SSD 6010 - One Residential Building (Student Accommodation) within Darling Drive Plot

**Submission by:**

**Urs Schaller and Channa Schaller**

**30 July 2013**

SHADOW DIAGRAMS: PERSPECTIVE, SHOWING THE PEAK, WINTER SOLSTICE

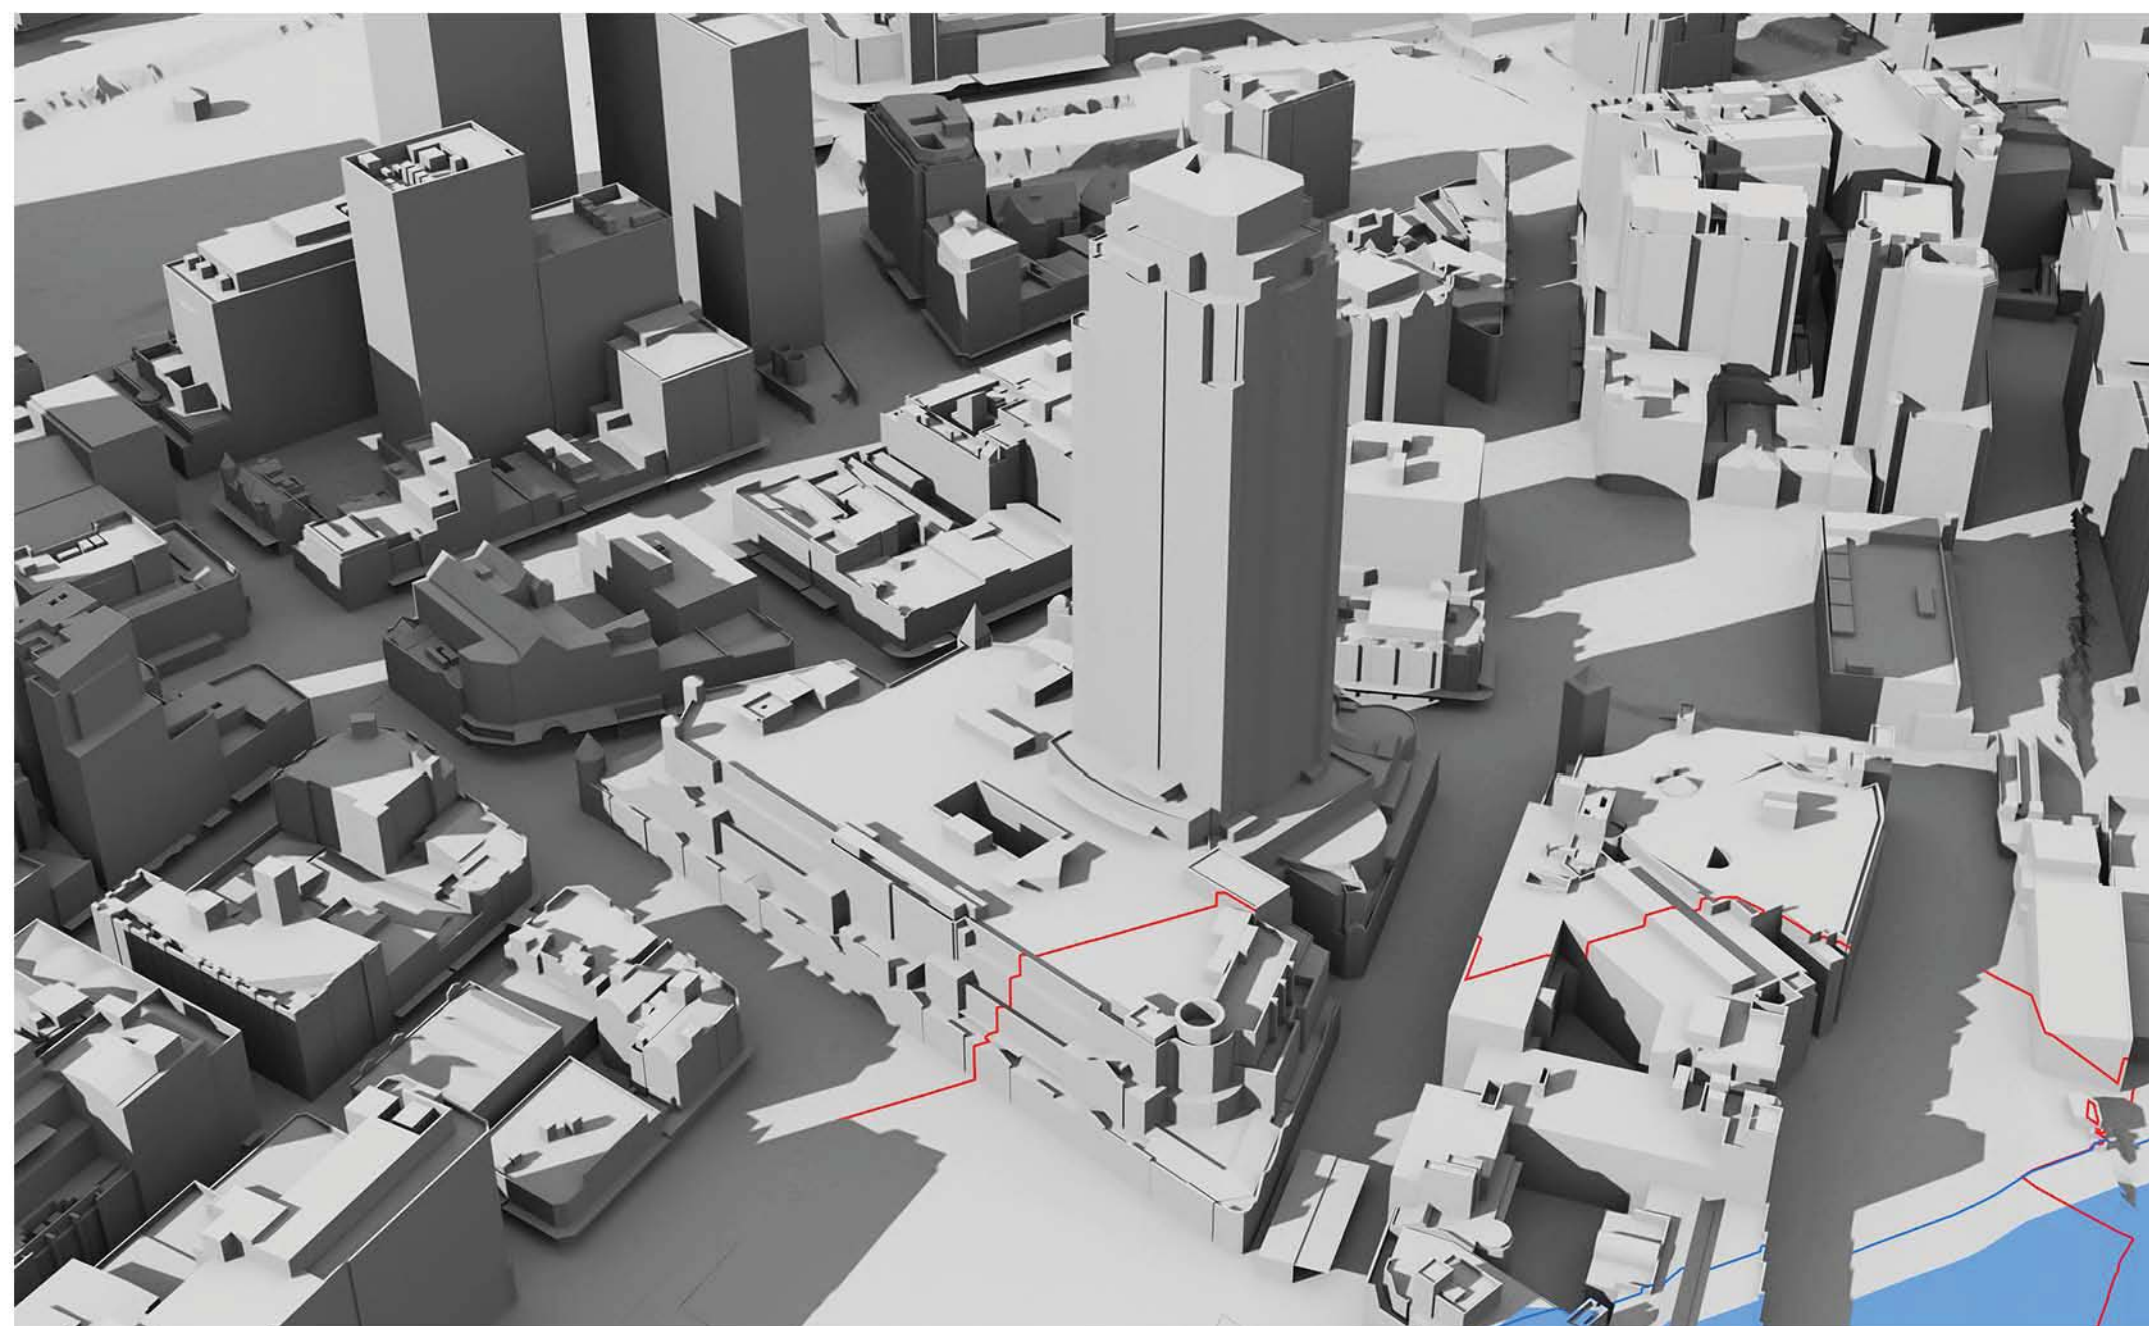
We refer to the shadow diagrams in SSD5878, Appendix H. Supplementary Design Report, Section 6. Amendments, Winter solstice - 22 June. This is not 21 June, but there would be no noticeable difference.

At 9am, 10am and 11am the west façade is totally in shadow due to other parts of The Peak building itself.

At 12pm there is still substantial existing shadowing on the west façade caused by the irregular shape of the west facade.

At 1pm the existing shadowing has been substantially removed, but not totally removed.

It can be concluded that some single aspect apartments on the west façade and some south-west dual aspect corner apartments currently receive less than 2 hours direct sunlight to habitable rooms and 50% of the private open space between 9am and 3pm on 21 June.

By 2pm the existing shadowing has been totally removed, but that is too late to achieve two hours of direct sunlight before 3pm.

At 9am, 10am and 11am the west façade is totally in shadow due to other parts of The Peak building itself.

At 12pm there is still substantial existing shadowing on the west façade caused by the irregular shape of the west facade.

At 1pm the existing shadowing has been substantially, although not entirely, removed. However, overshadowing of lower levels of the west façade by the concept proposal parameter plan shadows for the N,NE and SE plots has already started.

By 2pm the existing shadowing has been totally removed. However, overshadowing of the west façade by the SSDA4 and SSDA5 buildings has appeared and risen further up the west façade than the concept proposal parameter plan shadows for the N,NE and SE plots, which is still present.

At 3pm, the proponent states correctly that 45-45% of the western façade is overshadowed by the SSDA4 and SSDA5 buildings.

It can be concluded that, as a result of combination of the proposed development with existing shadowing of the west façade, some single aspect apartments on the west façade and the south-west dual aspect corner apartments which currently receive less than 2 hours direct sunlight to habitable rooms and 50% of the private open space between 9am and 3pm on 21 June will suffer additional overshadowing. It is beyond our skills to count the number of such apartments. We note that the proponent has made no attempt to do so.
